Application No: BR/272/13/

Recommendation Report for Planning Permission

LOCATION: Beach adj Bognor Regis Yacht Club
Victoria Road South
Bognor Regis

PROPOSAL: Construct a replacement launching ramp on the beach. This application affects the character and appearance of Aldwick Road Bognor Regis Conservation Area

LOCATION PLAN 'ISSUE B'

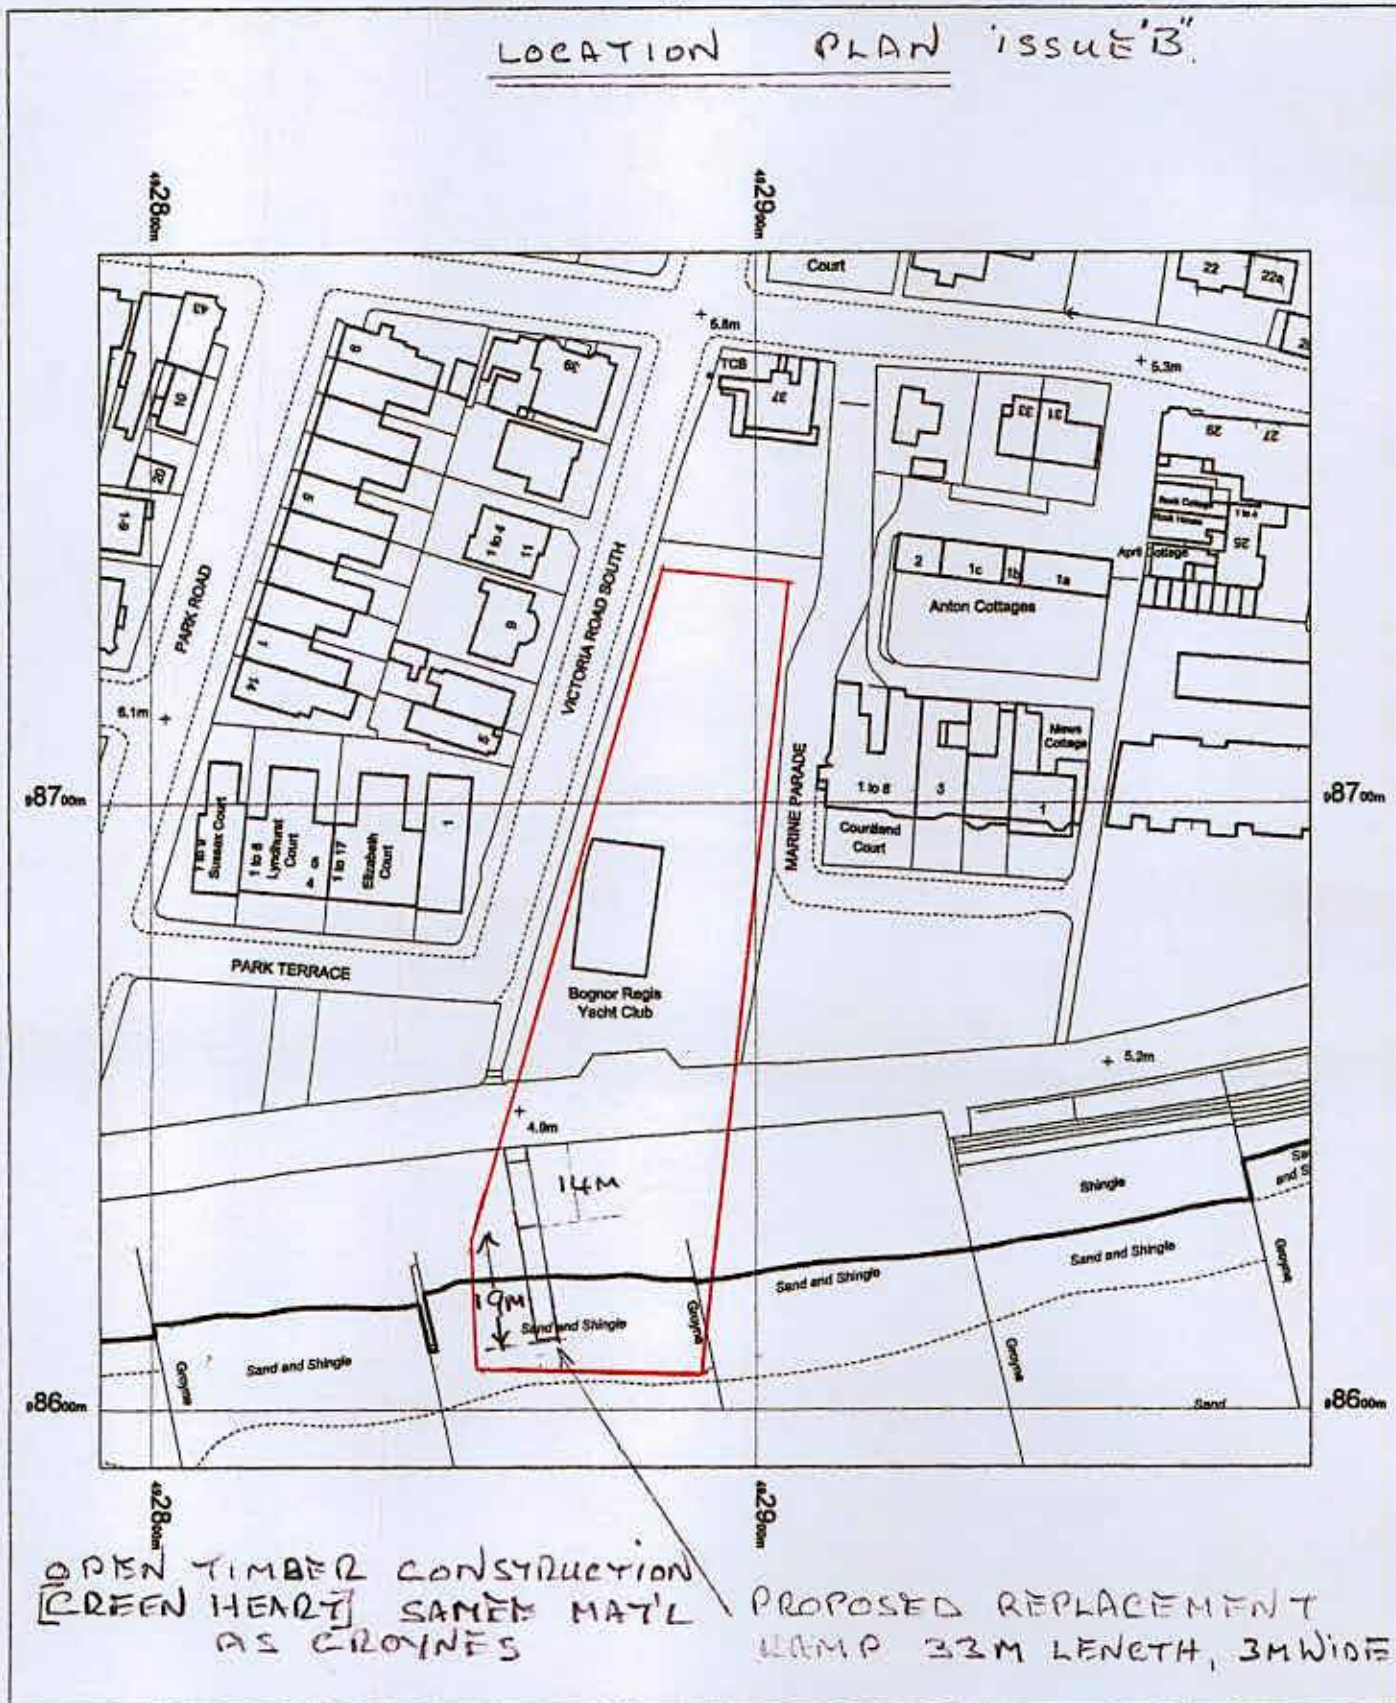
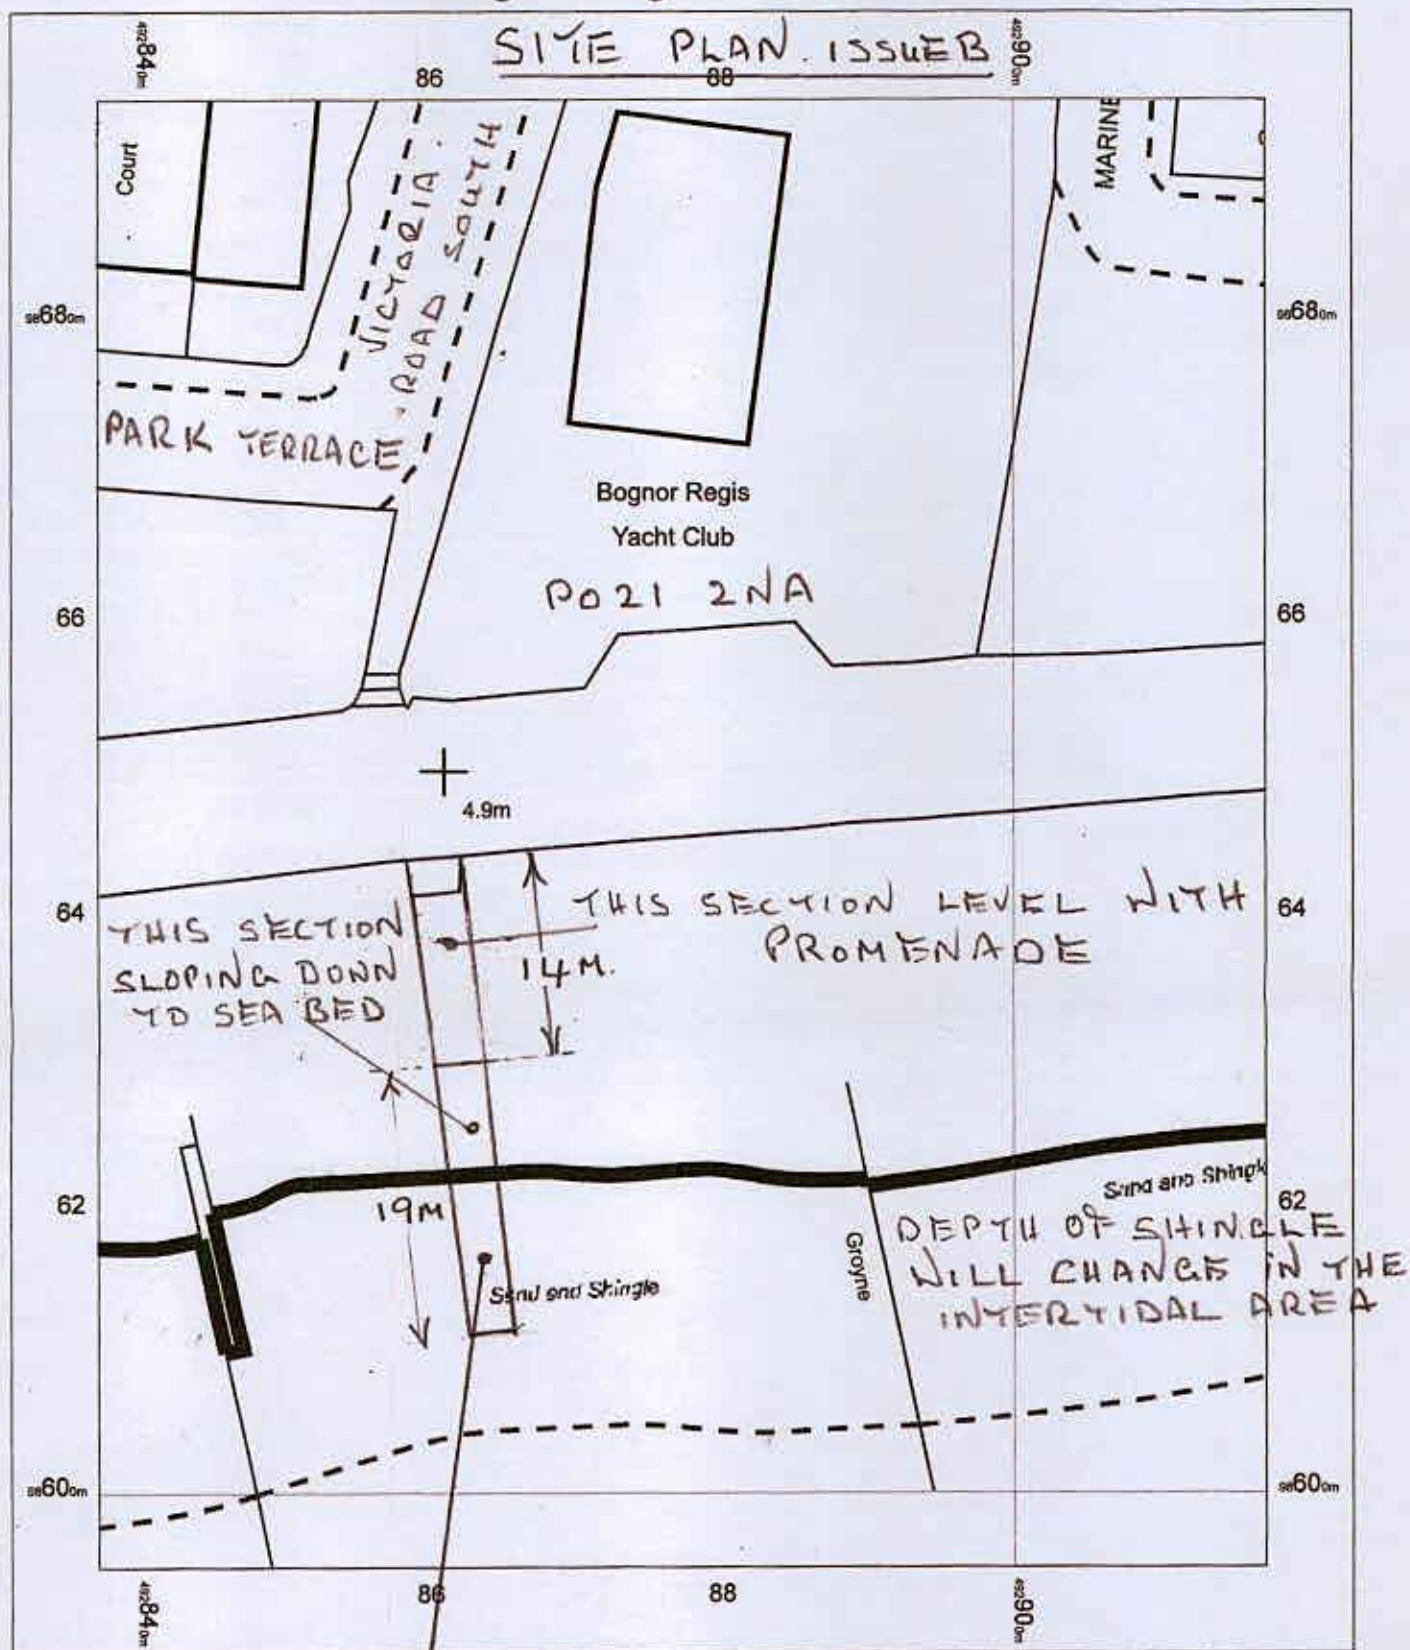
1. The ramp is to extend no further than the nearby outfall pipe (see photo in annex 1) in order to avoid impacting the movement of natural sediment;
2. Storage of plant machinery and equipment to be outside of the SSSI (i.e. on hard standing and not on the shingle beach);

Given the site's location on the shingle beach within the Bognor Reef SSSI, consultation has been undertaken with Natural England both before and during the application. Natural England have responded to state that they have no objections subject to confirmation that the ramp will not extend beyond the end of the adjacent outfall pipe and to a set of conditions designed to protect the shingle beach. The applicant has provided amended plans to show the ramp not extending any further than the end of the pipe.

Following extensive negotiation between the applicant and Natural England, it has been agreed that the ramp can be an extra 1m longer (i.e. only 1m shorter than as per the originally submitted drawing). Natural England has confirmed their agreement to this and amended plans have been received. This results in a change to the recommendation, namely the amendment of the plans condition (condition 02) to reflect the revised block and location plans (which are Revision C).

With the exception of the first condition (which is not capable of being a planning condition and for which amended plans have instead been provided), the remaining suggested conditions have been re-worded and form part of the recommendation. It should be noted that the change to the length of the ramp has resulted in a slight increase to the angle of the slope.
